Your Ref: MP 09\_0187 MOD 2

6 September 2013

**RE: SECTION 75W REQUEST TO FURTHER MODIFY APPROVED MIXED  
USE DEVELOPMENT PROJECT AT 6-16 ATCHISON STREET, ST  
LEONARDS (MP 09\_0187 MOD 2)**

GROUND LEVEL RESIDENTIAL ENTRY LOWER

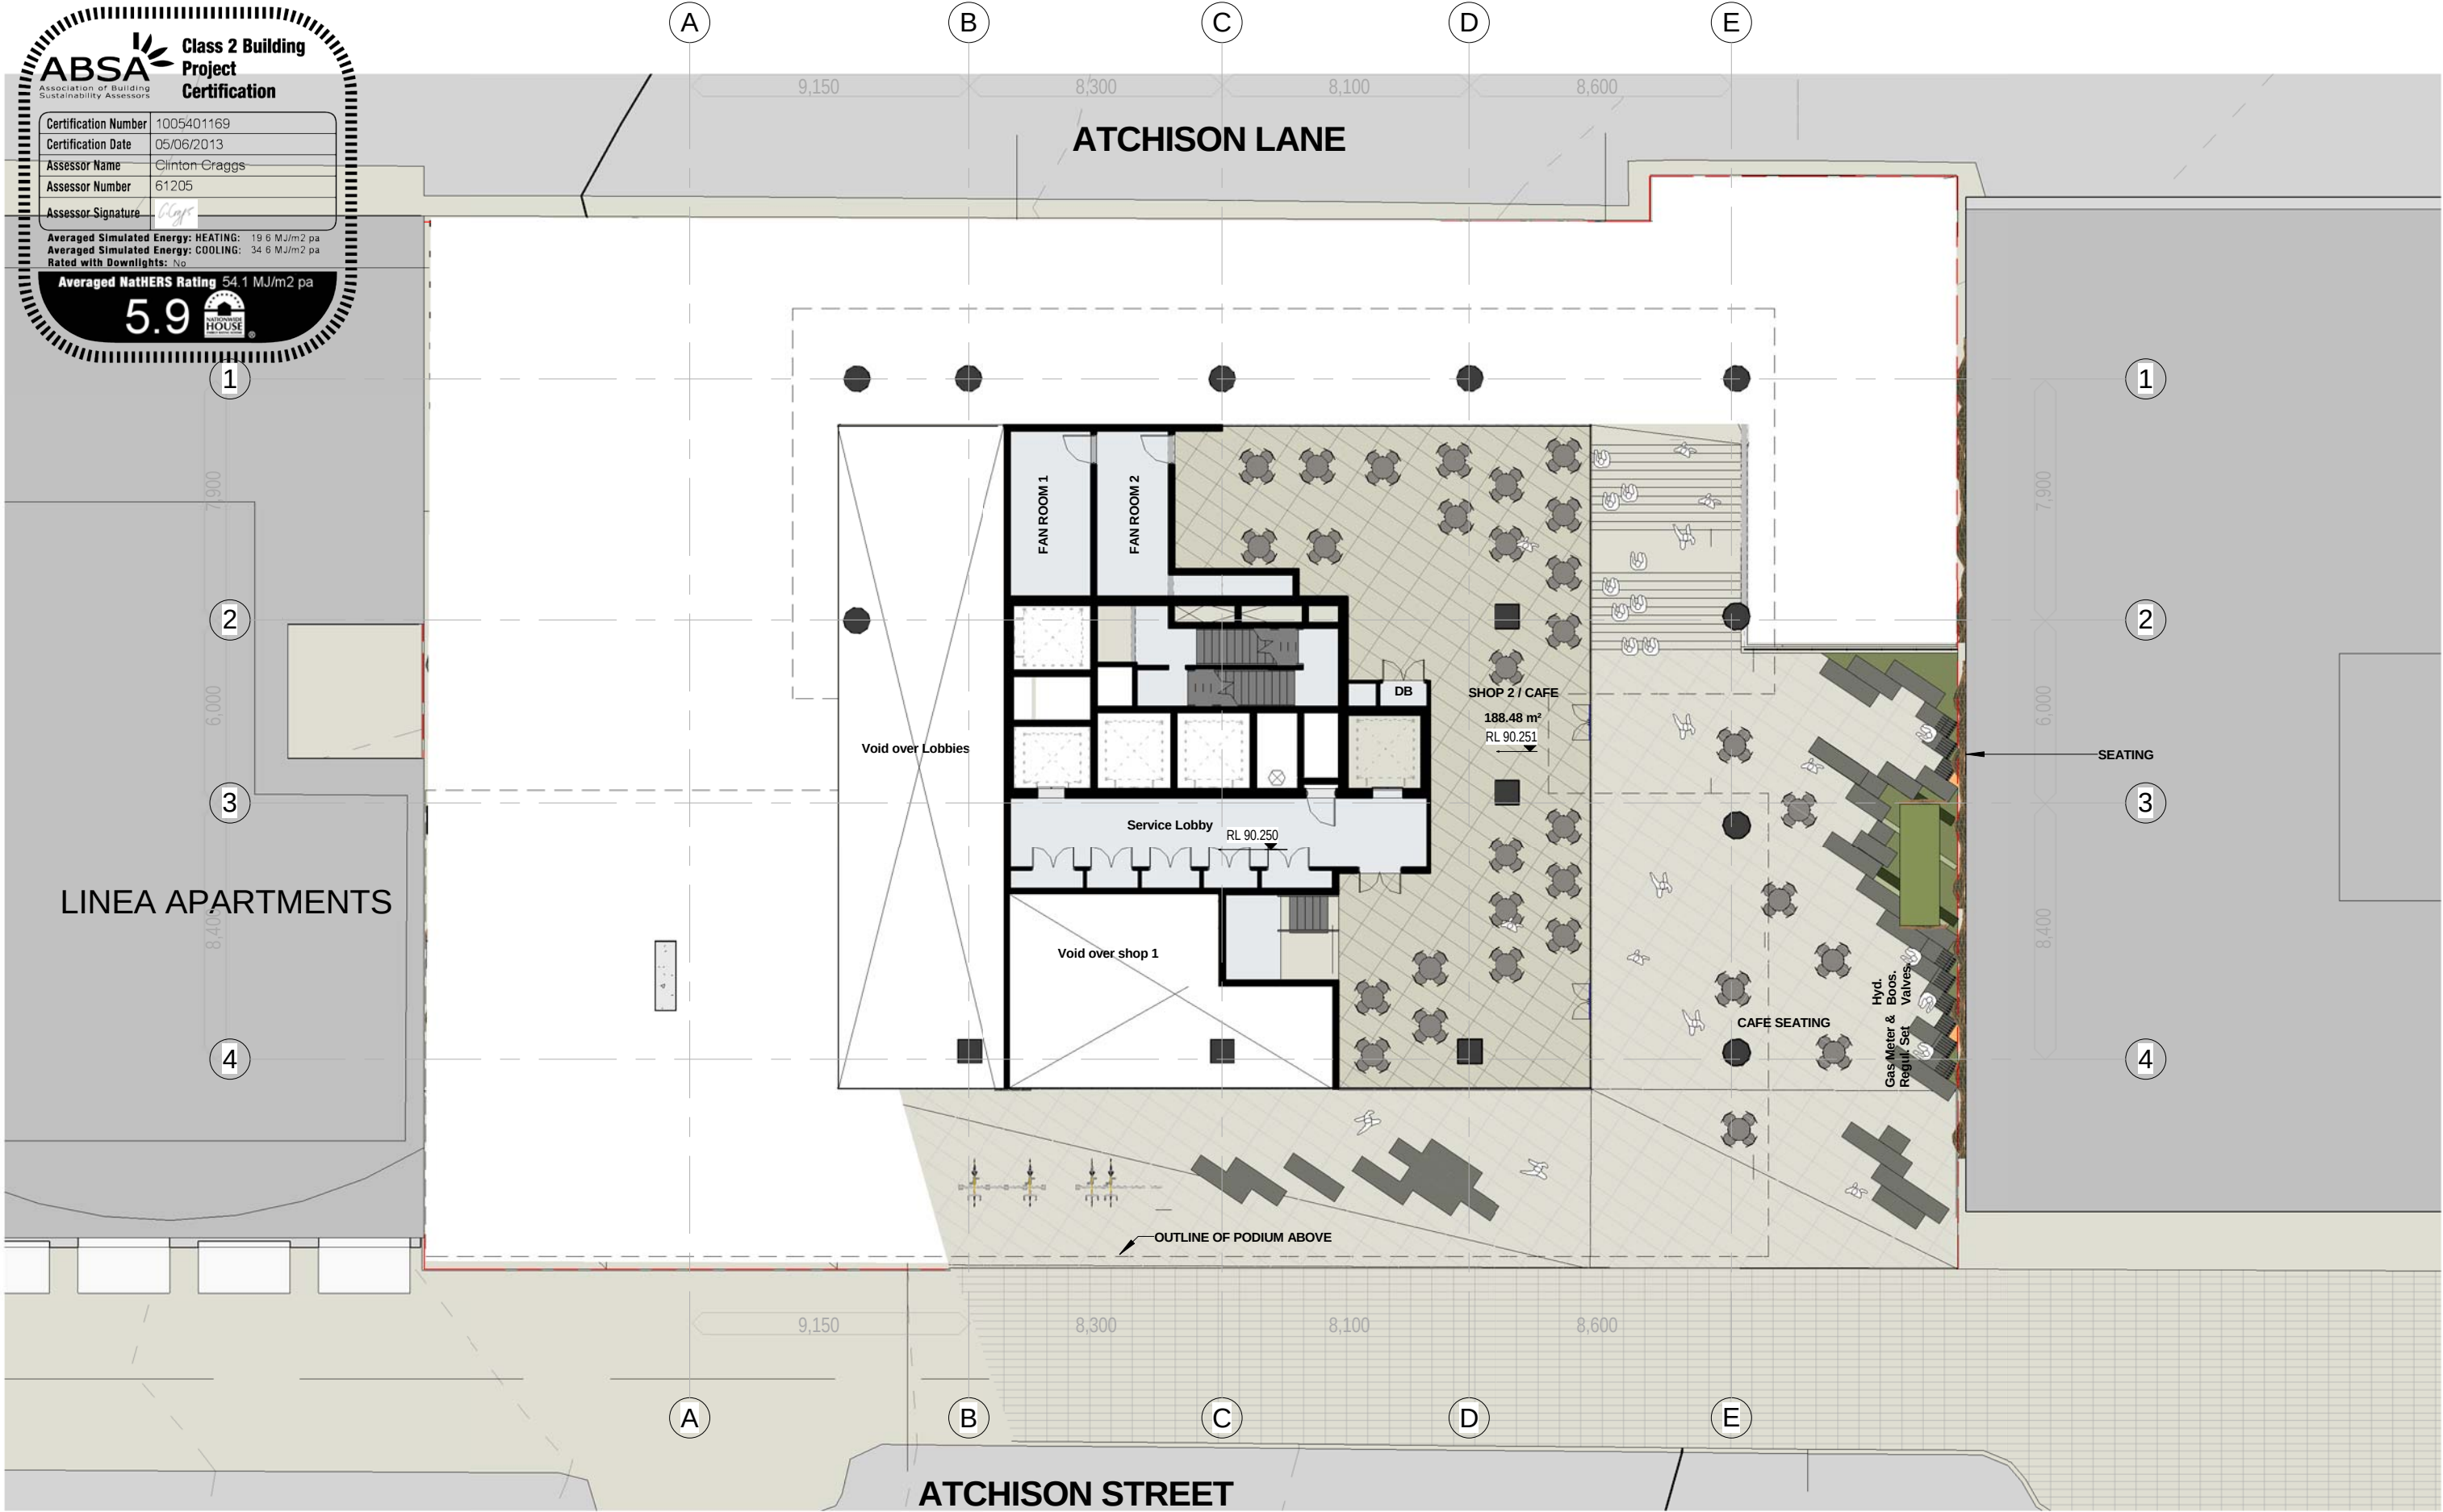
The modified plans propose that the main entry lobby will be shared between the residential and hotel (serviced apartments) components of this development. This is inconsistent with the guidelines for 'Building Configuration – Mixed Use' on page 80 of the *SEPP 65 Residential Flat Design Code*. These 'better design practice guidelines' provide that the commercial and residential components of mixed use developments should have clearly distinguished entries, vertical access points and servicing needs. Adherence to the recently renewed statutory controls would make this separation more appropriate. The amendment to the orientation of lift 3 does little to address this issue.

The modified plans do not comply with the requirements of condition B17 of the Project Approval. This condition requires the garbage storage area is to be provided with its entrance within 2m of a street, or if garbage storage facilities are provided elsewhere (as is the case with this modified proposal – the garbage and recycling storage area and compactor being located on basement level 1), then a complementary garbage bin holding area shall be provided no more than 2m from the street boundary of the property.

The modified plans are unsatisfactory in that the proposed garbage holding adjacent to the loading dock is totally inadequate to provide for temporary holding of compacted garbage bins for 200 apartments for the once per week collection by Council's waste collection contractors.

Council has concern generally about the changes in regard to the through site link from the street to the lane. The movement of the substation and siting of the loading dock has limited the pedestrian link and it is now uninviting and narrow for members of the public that are unable to use the stairs.

Council recommends that the area in front of the loading bay and under the pergola adjacent to the lane be used for temporary storage on the collection day.

LEVEL 3

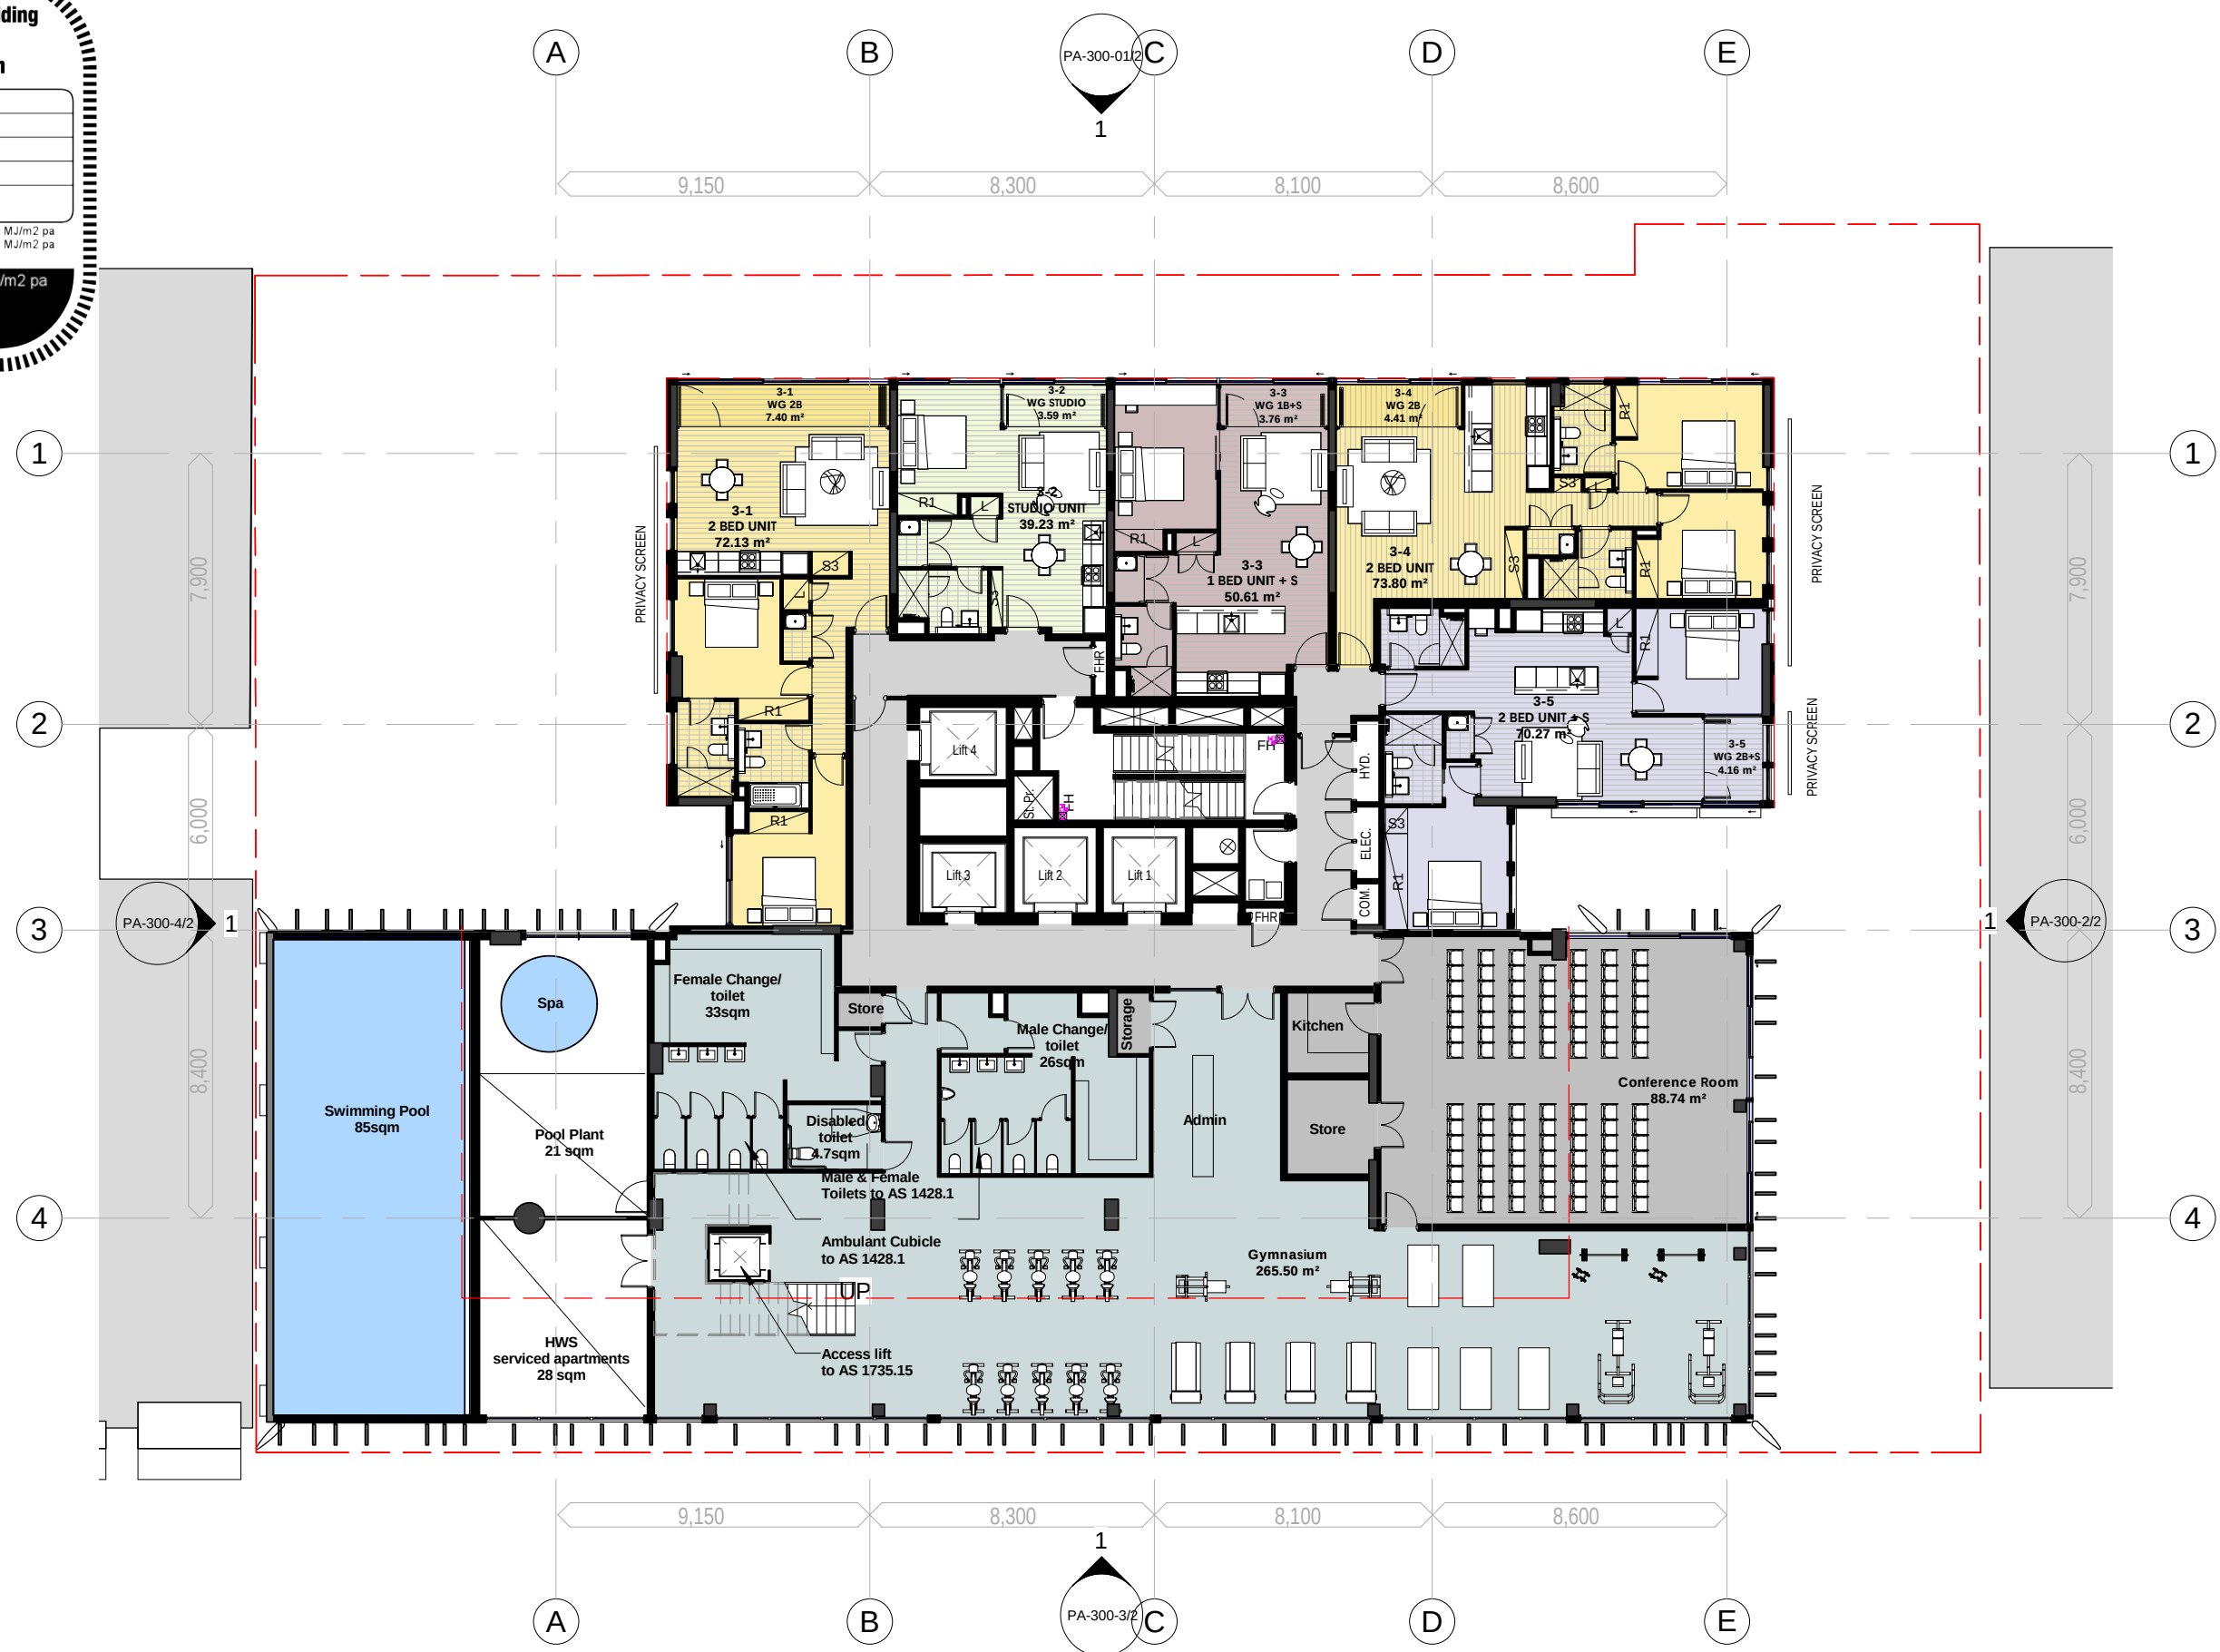
The site is zoned Mixed Use and it is important that the minimum non residential floor space requirements are achieved. Council recommends that the residential apartments on levels 3 and 4 form part of the serviced apartments as hotel and non residential floor area.
